DRB Application No.: 10DRB-7055 Project # 1003794
Project Name: VOLCANO POINT SHOPPING CTR
Agent: DAT JOSEPH Phone No.:

CITY OF ALBUQUERQUE
PLANNING DEPARTMENT
DEVELOPMENT REVIEW BOARD

10DRB-70155 MAJOR – SITE DEVELOPMENT PLAN FOR BUILDING PERMIT

PAT JOSEPH agent(s) for DOUGLAS PETERSON - PETERSON PROPERTIES request(s) the referenced/ above action(s) for all or a portion of Lot(s) 3, **VOLCANO POINT SHOPPING CENTER** zoned SU-2 FOR PCA (Planned Commercial Area), located on the west side of 98TH ST NW between CENTRAL AVE NW and VOLCANO RD NW containing approximately .7516 acre(s). (K-9)

DATE: 11-1-2006 sheet-  
SCALE: 1" = 40' of  
**AS1**

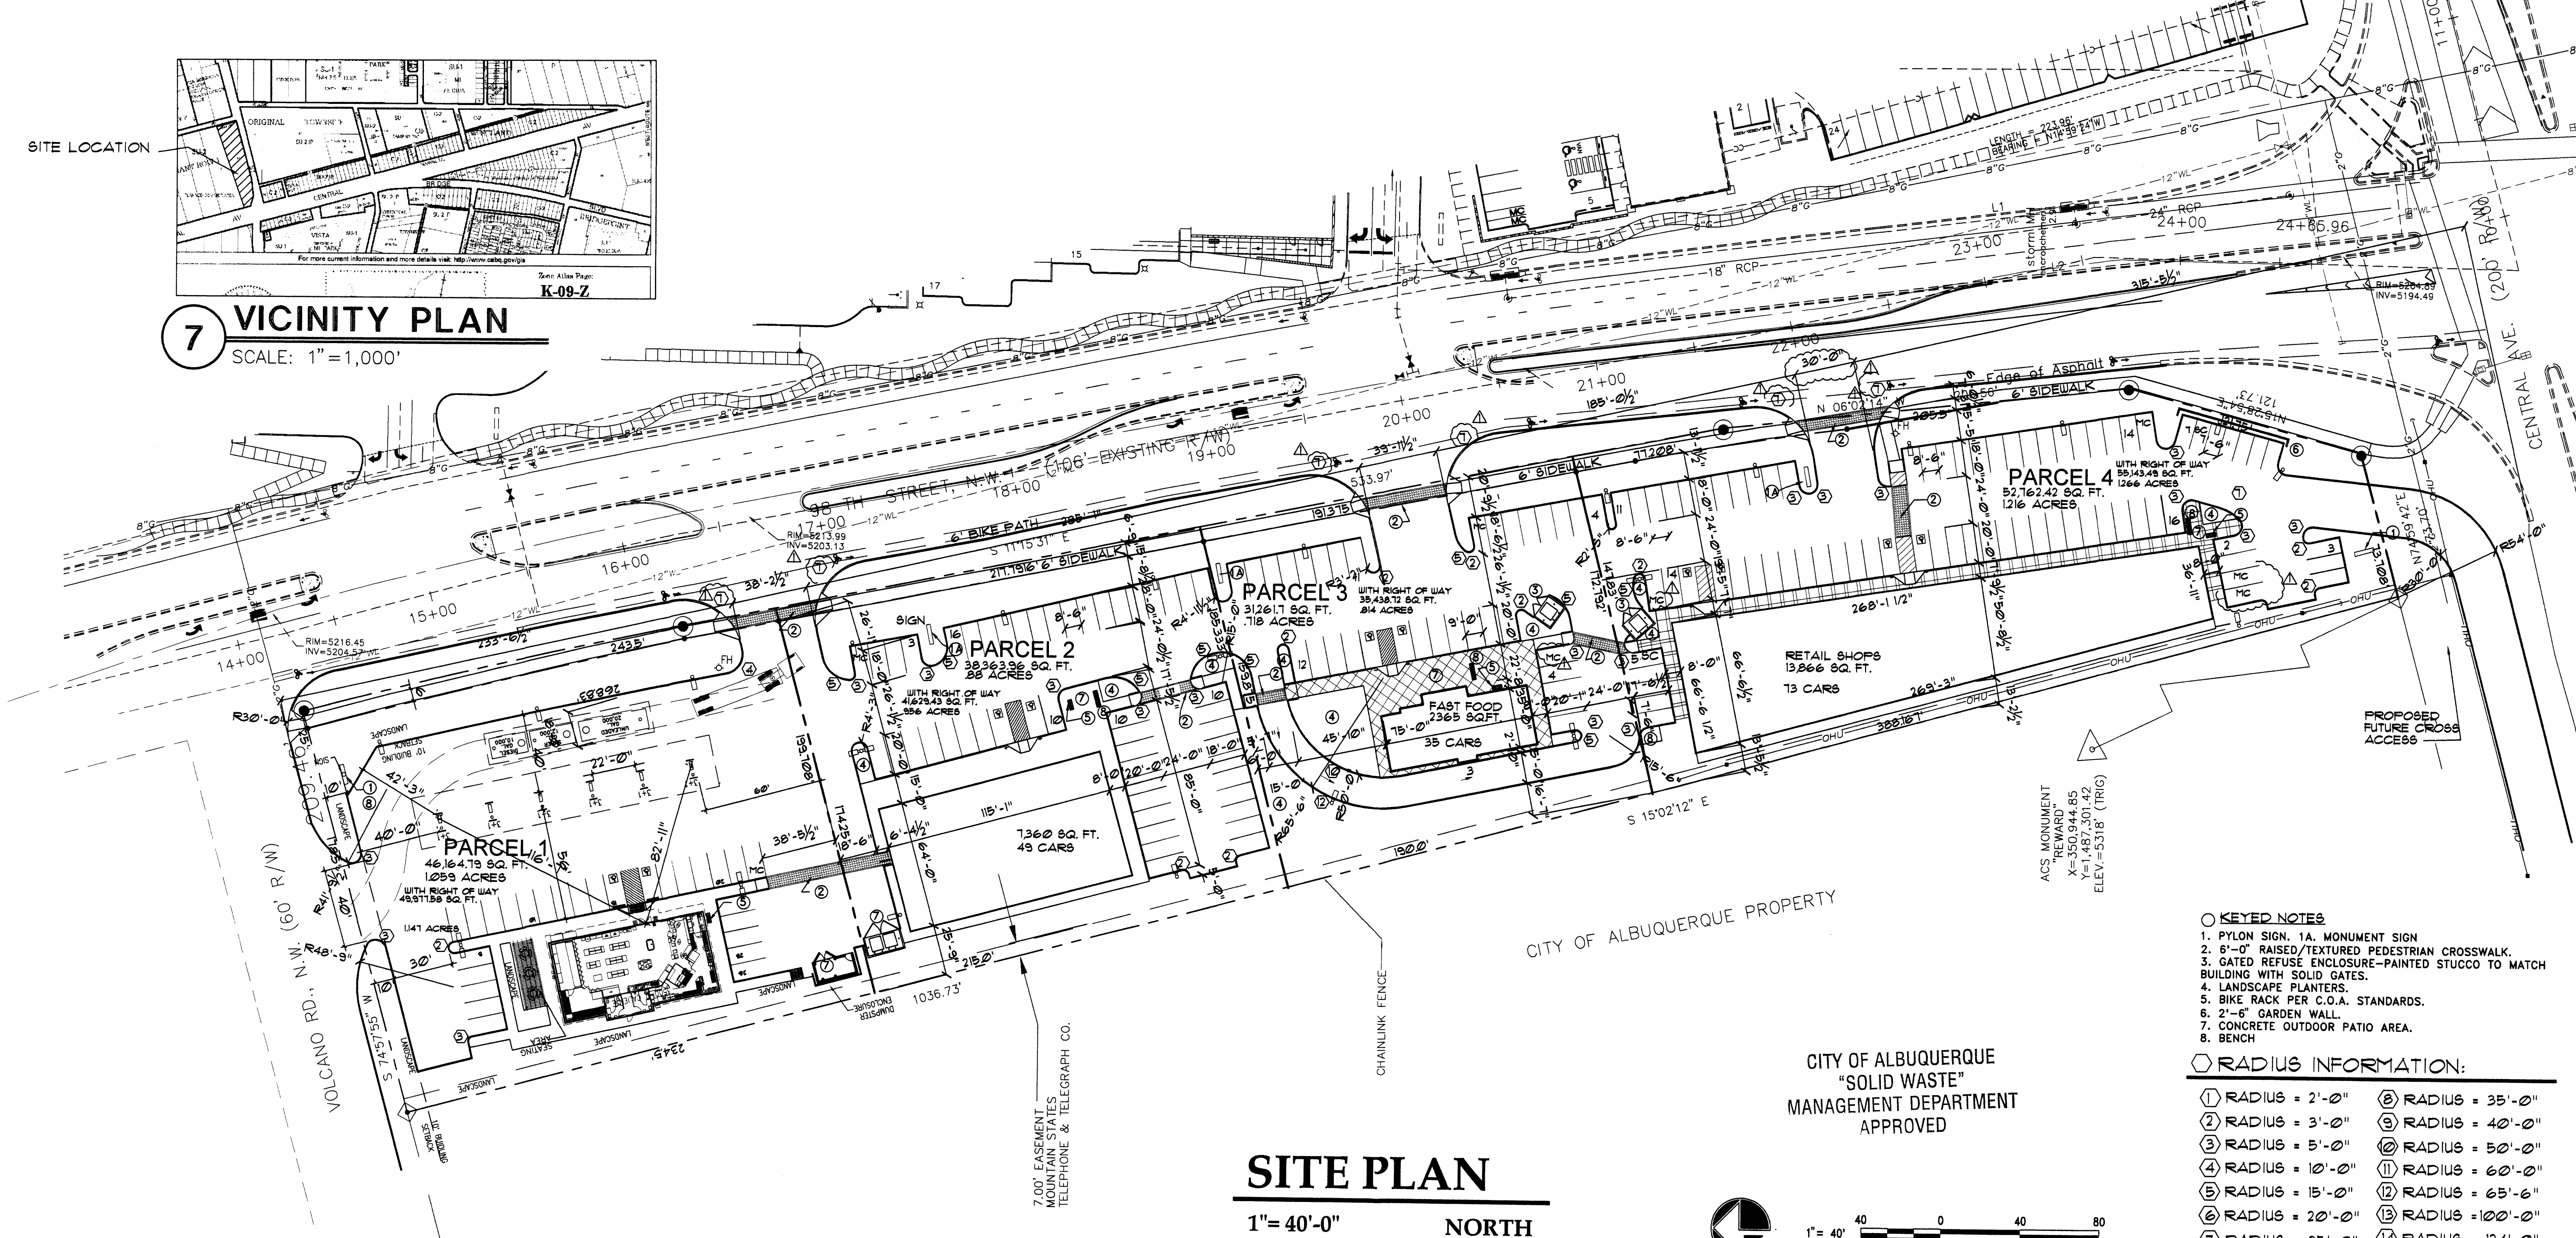
PARKS AND RECREATION No comment.
ABCWUA No comment.
PLANNING DEPARTMENT Sheet AS1 thru AS3 do not need to be part of this final site plan for building permit set. Sheet L1 needs to be replaced with Sheet L2 from Aug 28, 2008 approved site plan. 2 motorcycle parking spaces are needed per Aug 28, 2008 site plan (located at east end of parking row on south side of building). All of Sheet AS2 notations for monument sign needed to be noted on Sheet C3.. More specificity is needed for elevations – refer to Sheet A5.0 from Aug 28, 2008 site plan. Black and Red (as shown on color rendering) are not approved colors per Sheet AS2 – again, refer to Sheet A5.0/ Aug 28, 2008. Building mounted signage material and colors need to be specified.

C1

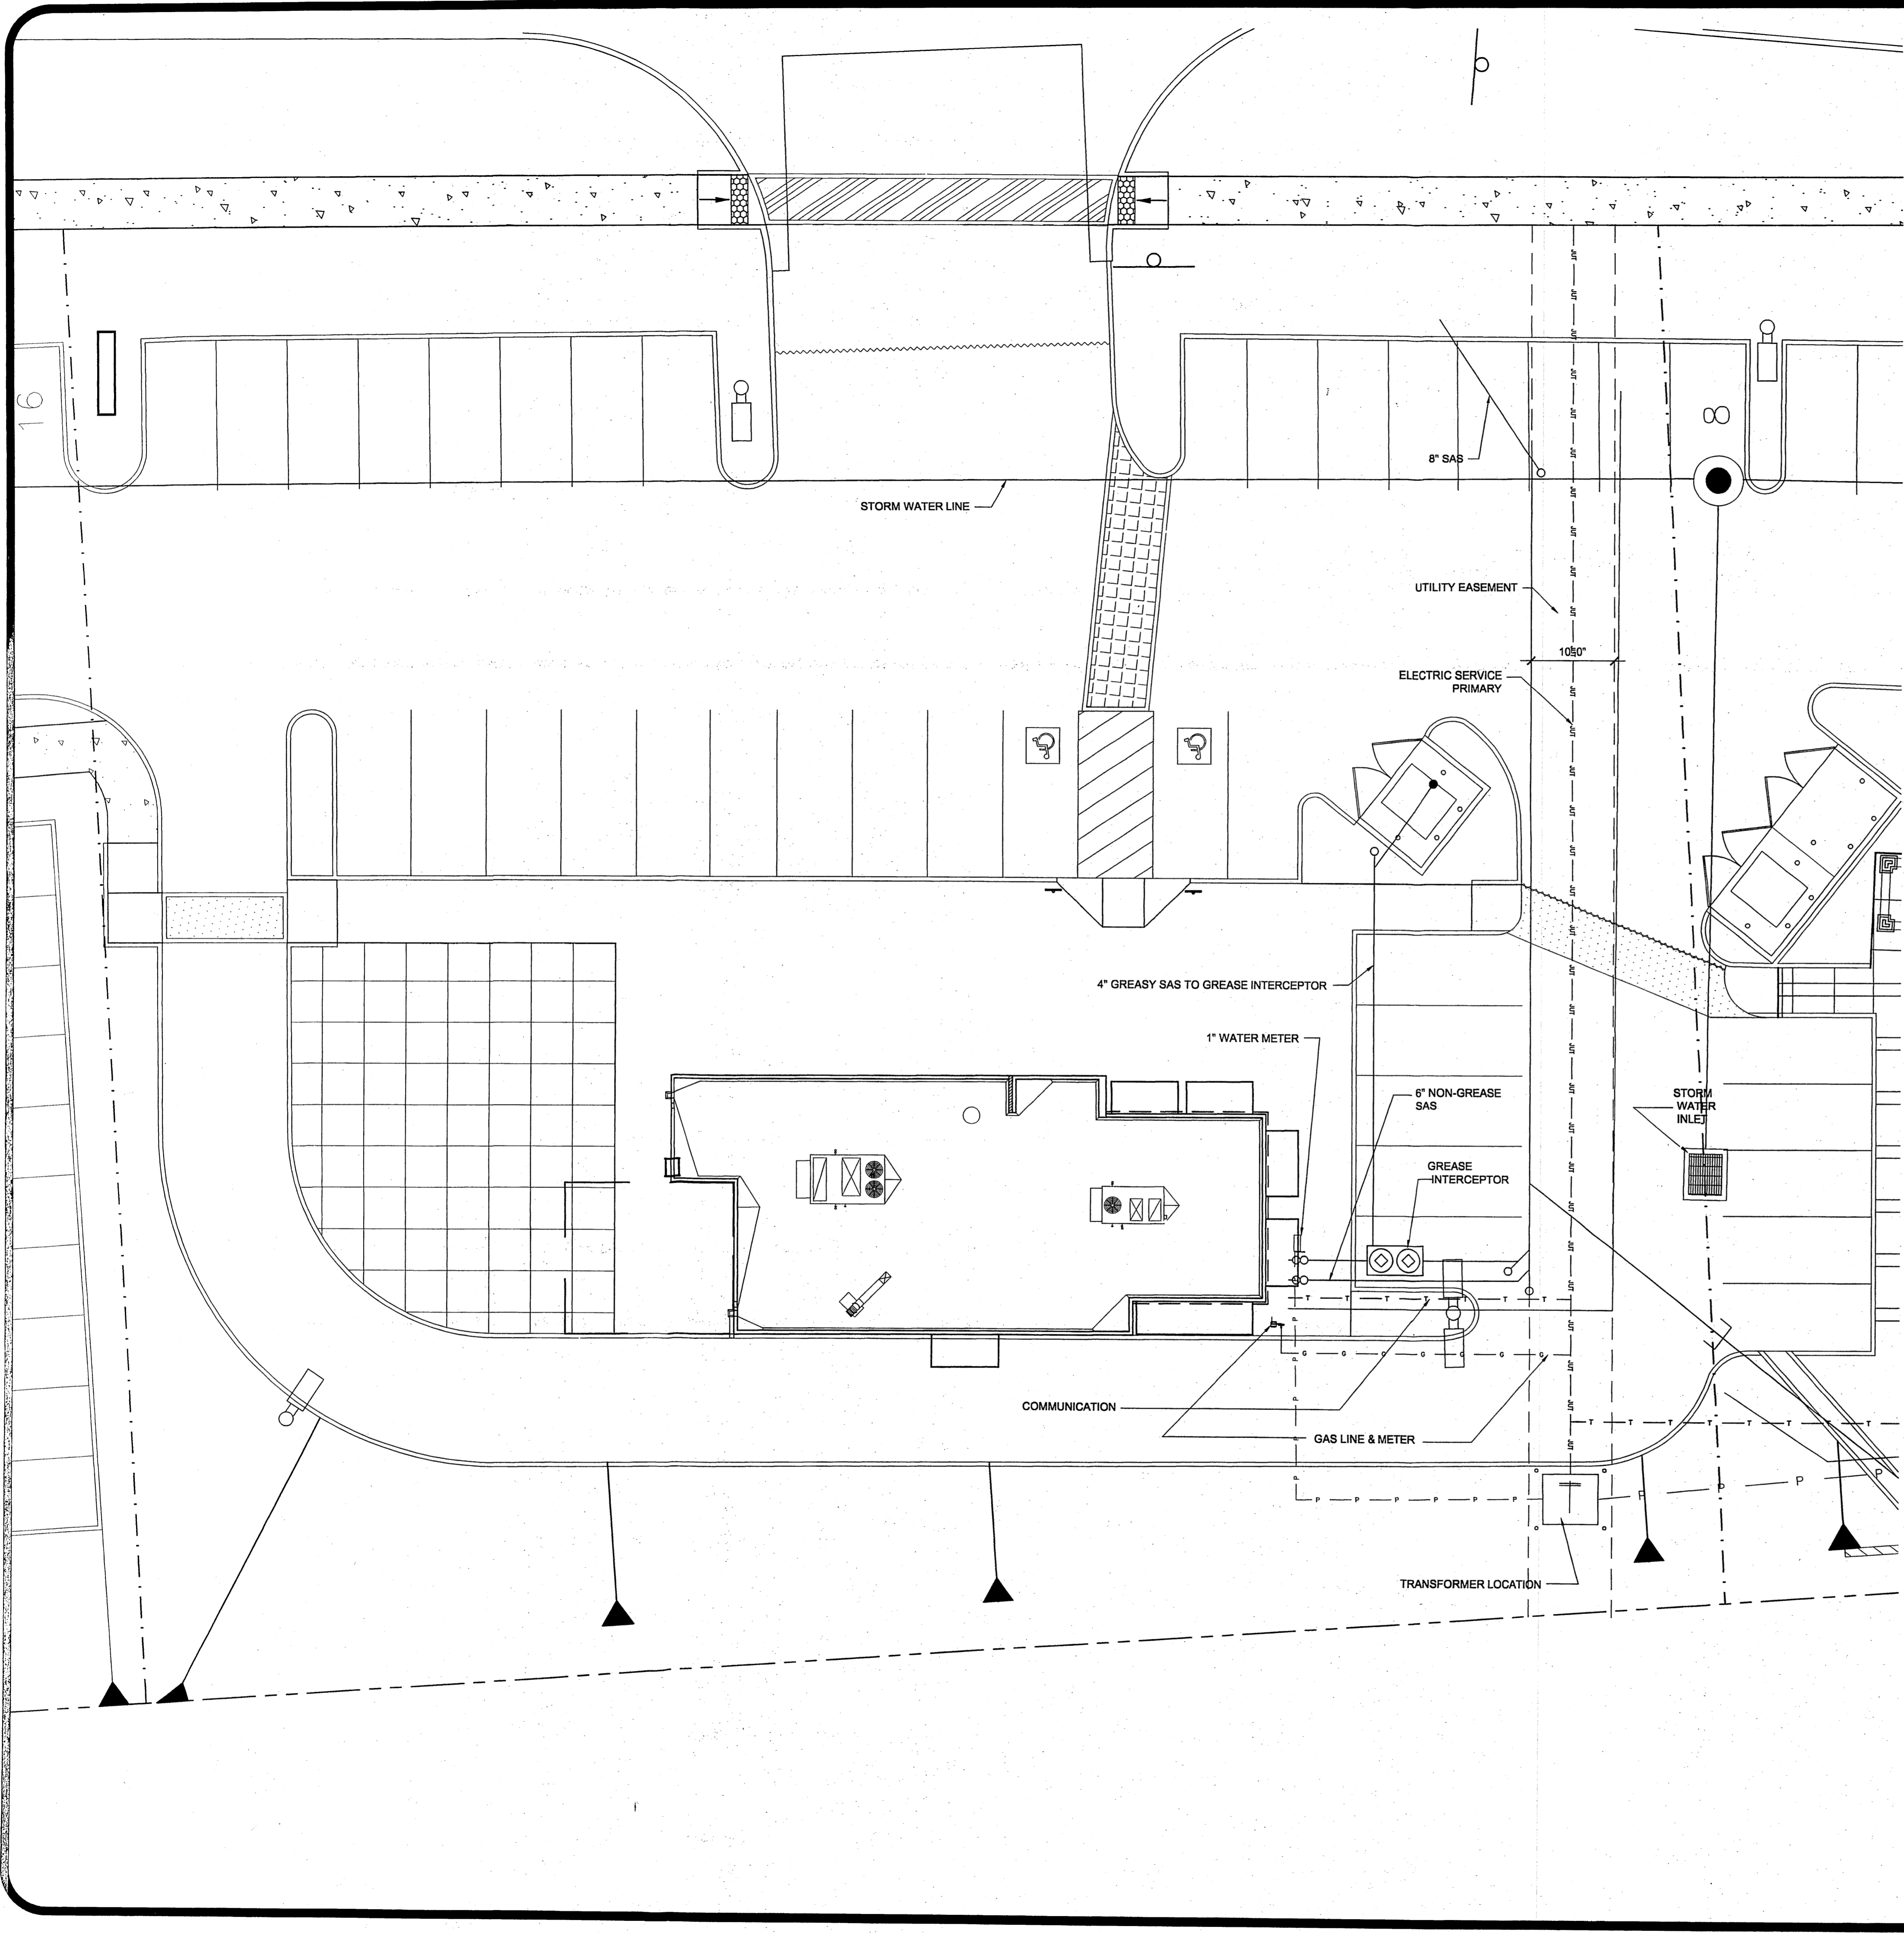
Exterior lighting does not appear to be adequate. Suggest adding pole lights at the beginning of the drive-through driveway (reduce access to vehicles not moving, with ~~door~~ windows open, etc), at the drive up window (point of sale) and adjacent to trash dumpster.

Landscaping trees appear to be in conflict with pole lighting. Recommend not placing trees and pole lights in the same general area.

FIRE DEPARTMENT No comment.
PNM ELECTRIC & GAS No comment.
COMCAST No comment.
QWEST Concerning the subject case number(s), Qwest has no adverse comments at this time provided all utility easement rights are maintained. Prior to any final plat approval, we will need a copy for review.
ENVIRONMENTAL HEALTH No comment.
M.R.G.C.D No Adverse Comments
OPEN SPACE DIVISION Open Space has no adverse comments
CITY ENGINEER No adverse comments.
TRANSPORTATION DEVELOPMENT Clarify existing versus proposed conditions. Club Cmt #1 Call out all radii; for passenger vehicles, the minimum end island radius is 15 feet. Show all ramps and provide details. What is the purpose of the one directional arrow shown? Call out the width of all sidewalk, existing and proposed. Indicate the site location on the vicinity map. Define and provide recording information for the existing cross access easement. "Do Not Enter" striping and/or signing must be provided at the drive through exit.
